Re: SSD-62855708 - Proposed Waste Management Facility at 2-4 Hale Street, Botany

Coombes Property Group (Coombes) has reviewed the comments received from the Department of Planning, Housing and Infrastructure (DPHI) dated 29 July 2025, and from Bayside Council dated 12 May 2025, regarding the State Significant Development (SSD) application (SSD-62855708) for the proposed Construction and Demolition (C&D) Waste Management Facility at 2-4 Hale Street, Botany.

Site Plan (Rev. L)

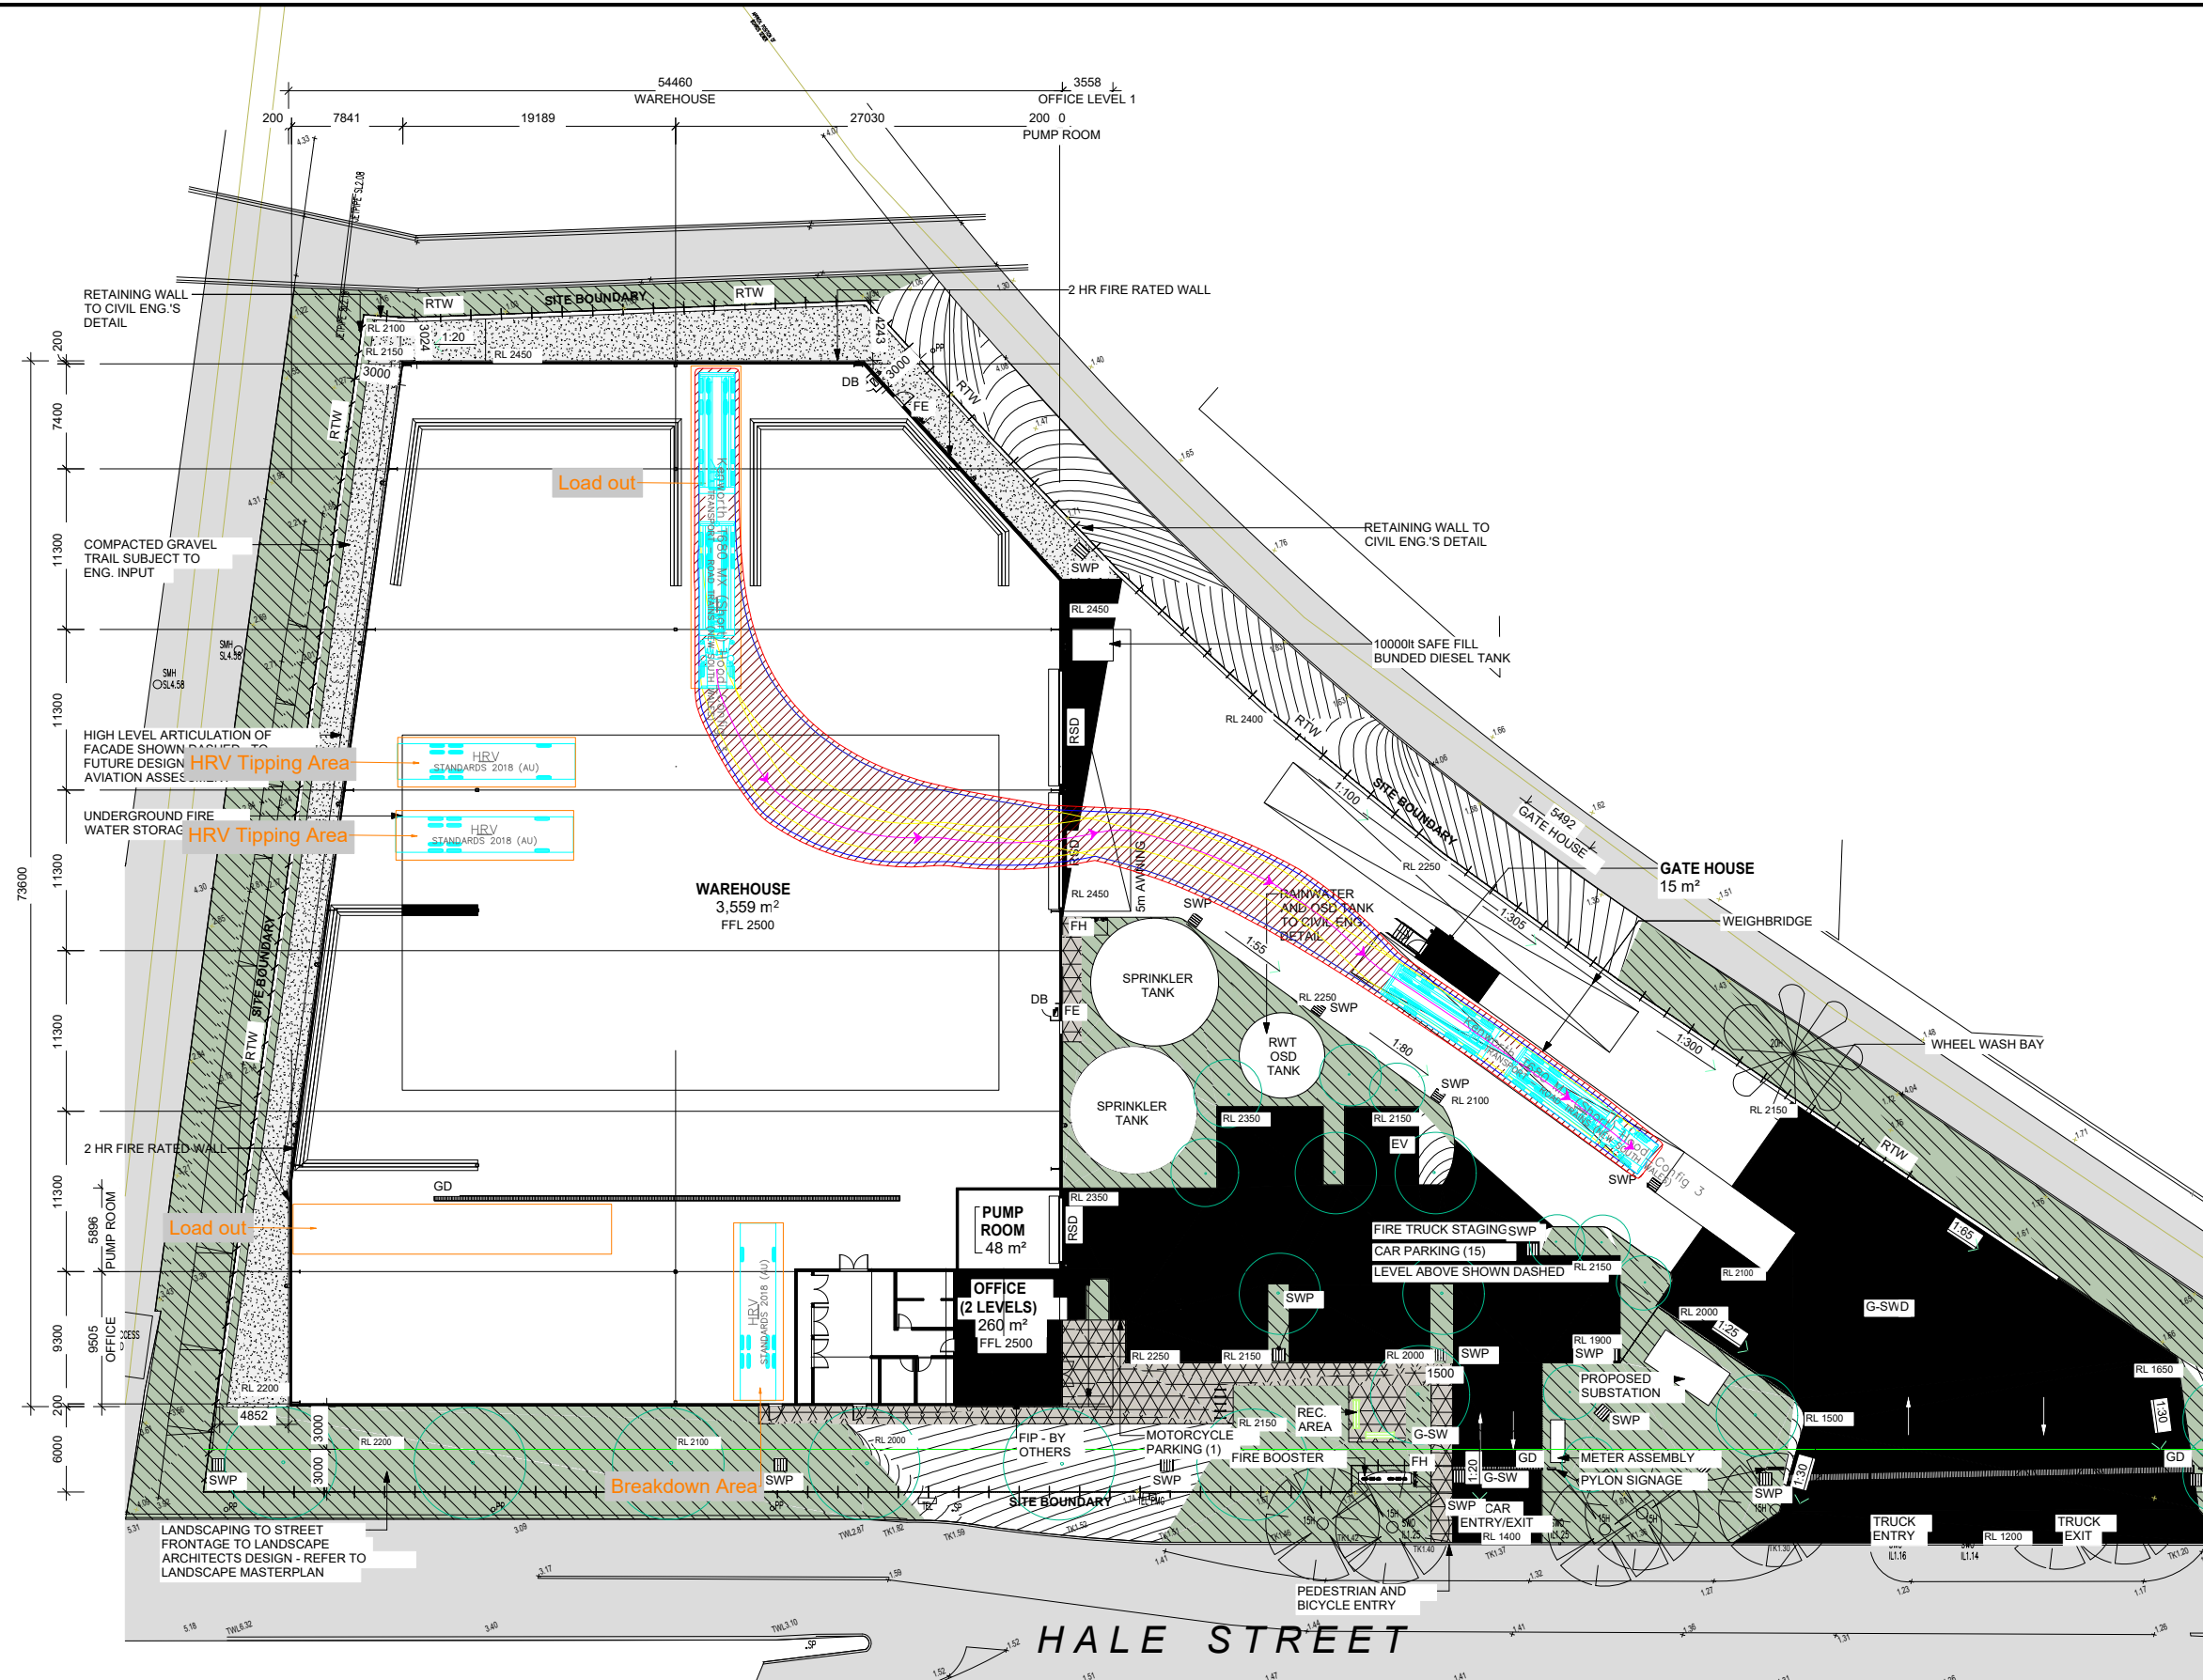
Details of management measures / contingencies to be adopted to ensure queuing does not occur on the site in the event of a malfunction or breakdown or other unexpected operational scenarios. Coombes must commit to implementing these measures as part of an operational traffic management plan – where possible, the effectiveness of these measures is to be documented based on existing KLF operational experience.

Clear evidence-based demonstration that the queue of trucks on the site will continue to move despite unloading stages taking longer than the incoming vehicle inspection stages. This should include truck dwell time data for review.

Details of how trucks collecting waste will not conflict with incoming vehicles unloading waste – to be supported by commentary and figures clearly demonstrating how this will be achieved.

Swept path analyses have been prepared to demonstrate the ability to tip two medium trucks simultaneously, reducing tip floor dwell times and, consequently, minimising waiting times for queued vehicles (refer to Appendix 1). Additionally, a holding bay for one RHV (12.5m) has been incorporated into the facility layout, allowing one RHV to be accommodated on site in the event of unexpected situations.

Modelling in TIA v13 demonstrates that the site can accommodate a queue of up to seven (7) B-Doubles (equivalent to 14 HRVs) without operational constraint, even if unloading durations exceed inspection times.

Swept path analyses (refer to Appendix 1) demonstrate the physical separation of loading zones and waste tipping traffic flows, ensuring there are no crossover points where inbound and outbound trucks share the same operational lane at the same time.
